Application by Highways England for the M25 Junction 28 improvement scheme (the Proposed Development)
The Examining Authority's Written Questions and Requests for information (WQ1)
Issued on Wednesday 13 January 2021

Responses are due by Deadline 2: Thursday 4 February 2021

Project Title	M25 Junction 28
Drawing Title	FIGURE 5.2 STUDY AREA FOR CONSTRUCTION DUST ASSESSMENT
Drawing Number	HE551519 - ATK - EAQ XX - GS - GI - 000002
Original Size	A3
Scale	1:16,000
Project Ref. No.	---
Sheet	1 of 1
Rev.	C03

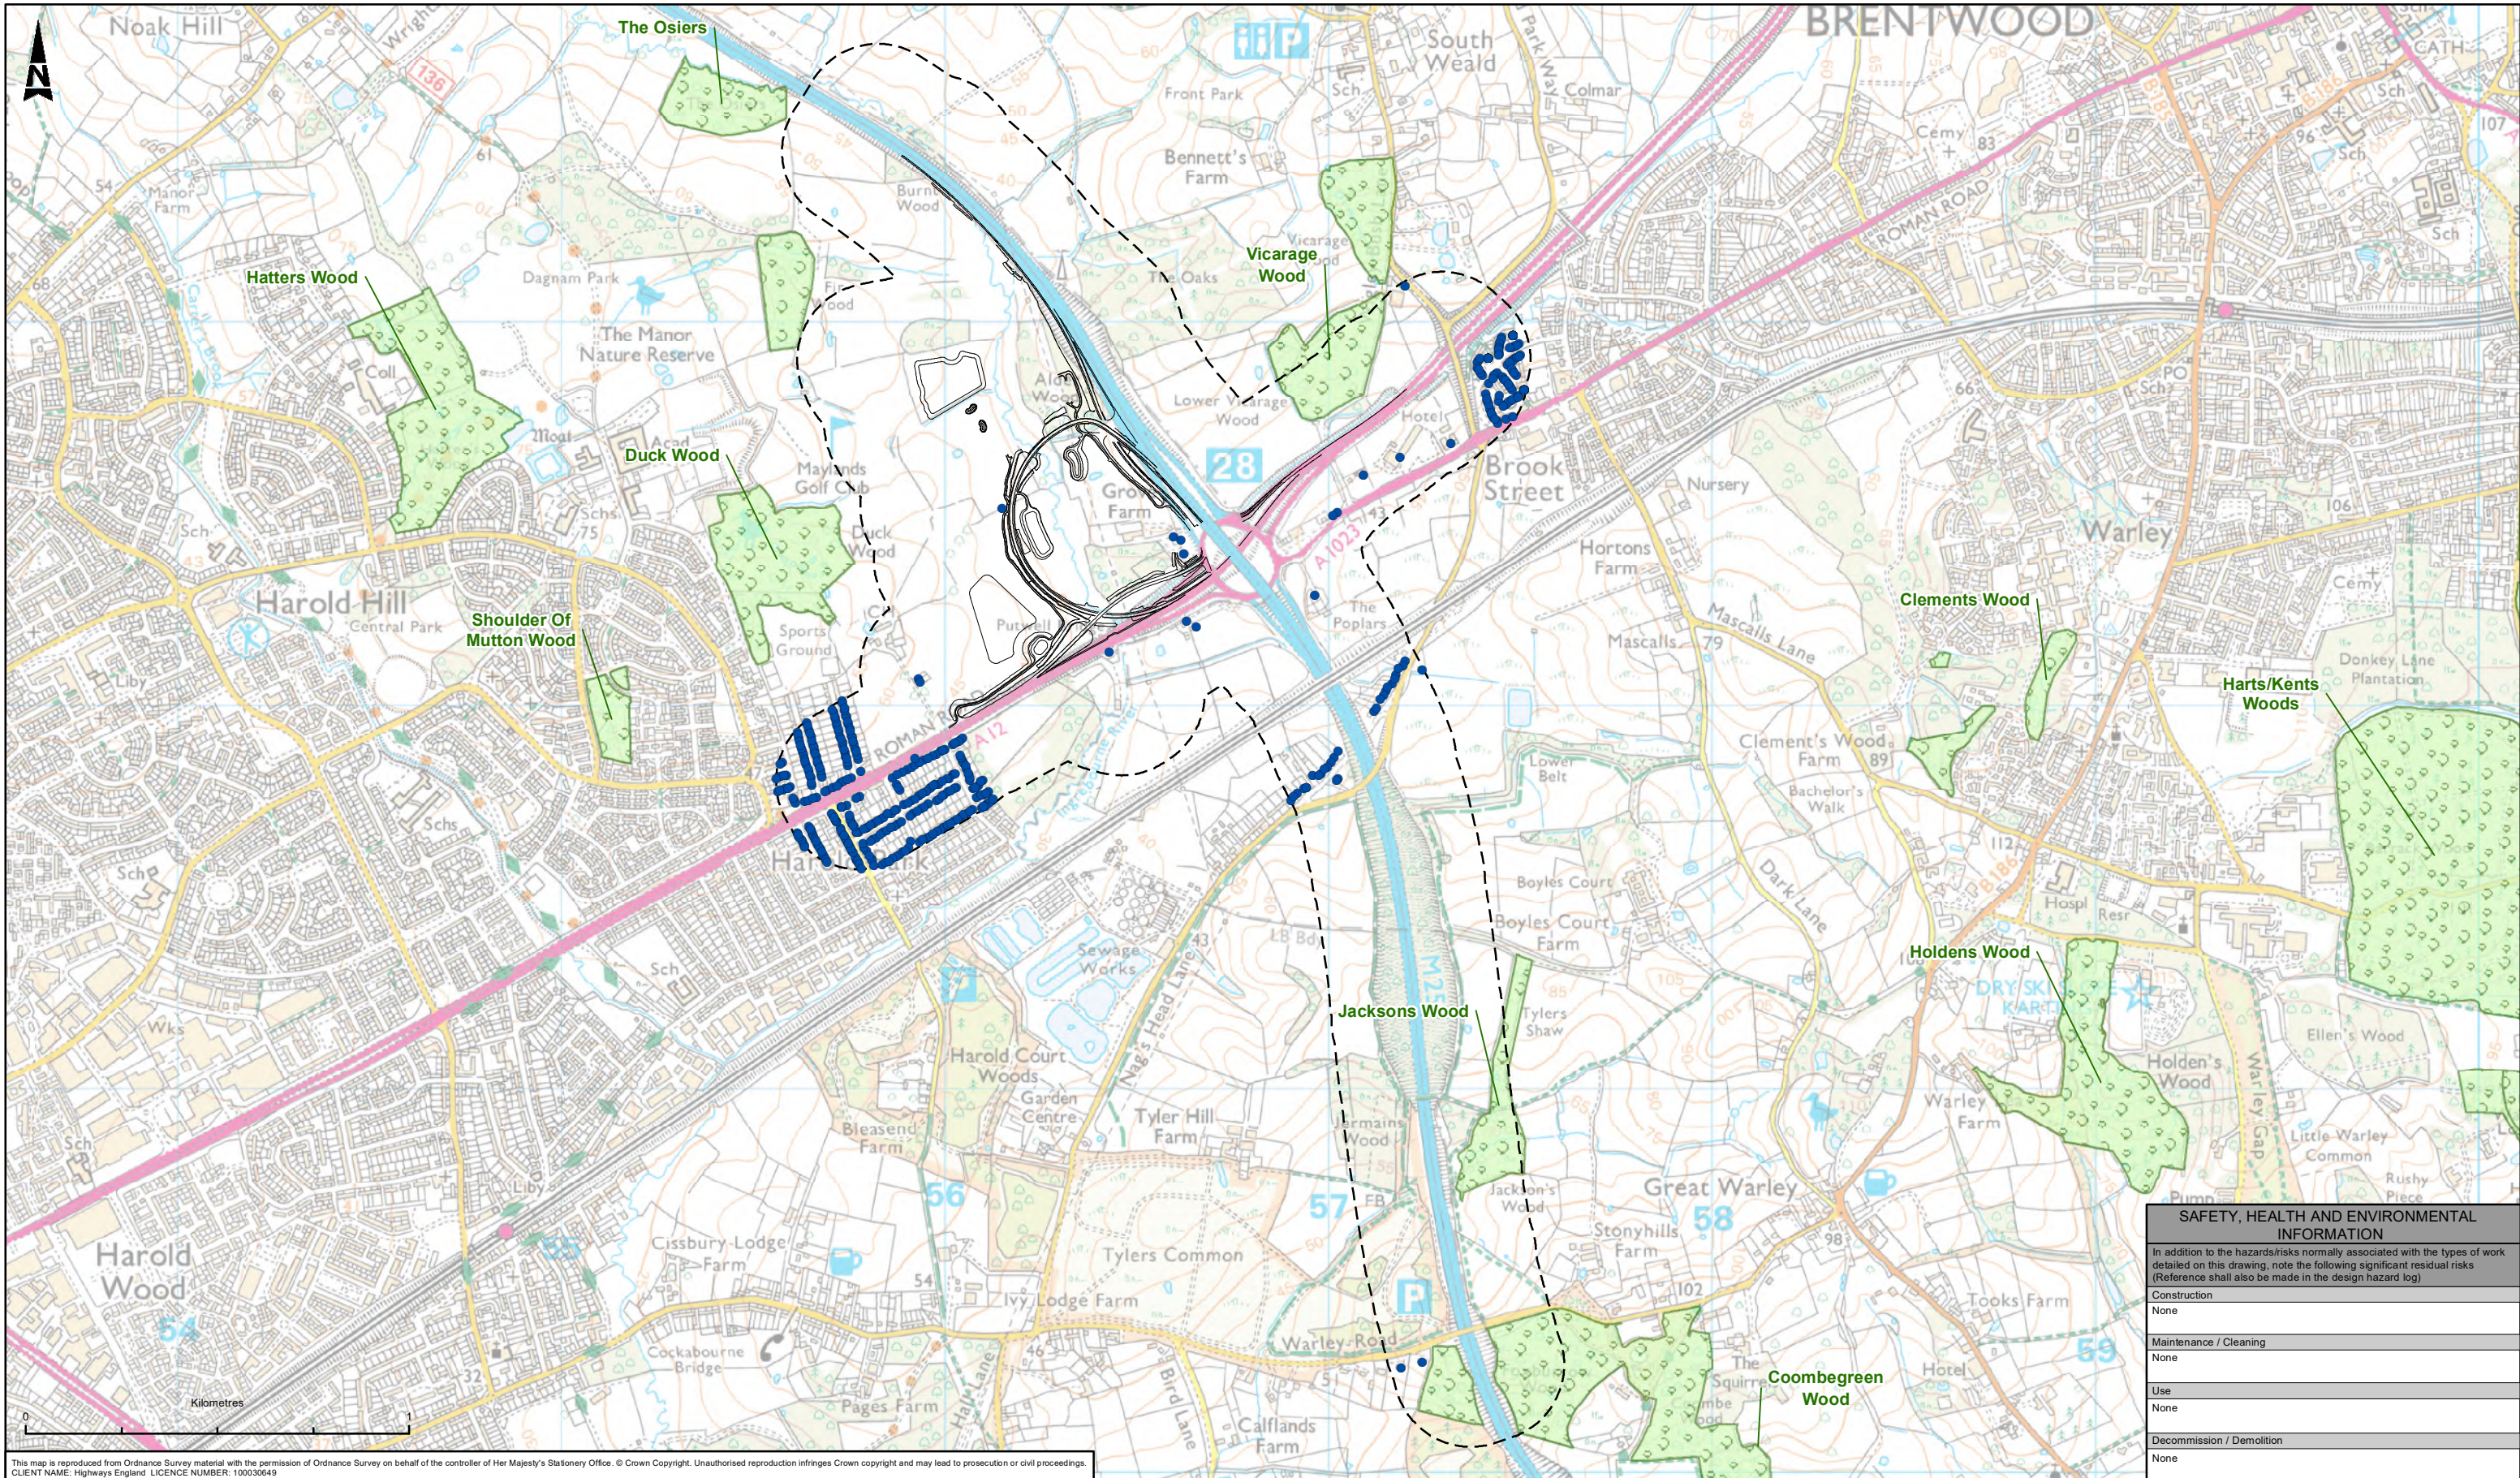
AQ	Air Quality		LB Havering Responses
AQ 1.1	<i>Baseline Assessment</i> The Applicant	Figure 5.2 of the Air Quality Figures accompanying Chapter 5 of the ES [APP-040] presents receptors sensitive to construction dust and highlights the ancient woodland surrounding the site. However,

<p>some of the highlighted ancient woodlands are outside of the construction dust study area so it is unclear if these are included as receptors or not. Furthermore, Figure 5.2 does not illustrate other ecological receptors, such as Local Nature Reserves (LNR) and Local Wildlife Sites (LWS) that are within the study area. These receptors are shown on Figure 7.3 [APP-042].</p> <p>In addition to information provided within Chapter 5 of the ES [APP-027], clarify where receptors sensitive to construction dust and other ecological receptors that have been assessed are with respect to the Proposed Development, provide a figure that contains the following:</p> <ul style="list-style-type: none">- The Order limits.- The construction and dust air quality assessment study areas.- Relevant sensitive human and ecological receptors.	
AQ 1.2	<i>Baseline Assessment</i> The Applicant	Chapter 5 of the ES [APP-027] makes no reference to consultation with Statutory Consultees, stakeholders or IPs in regard to the baseline data. However, paragraphs 5.7.25 and 5.7.26 state that some receptors (listed in paragraph 5.7.25) have
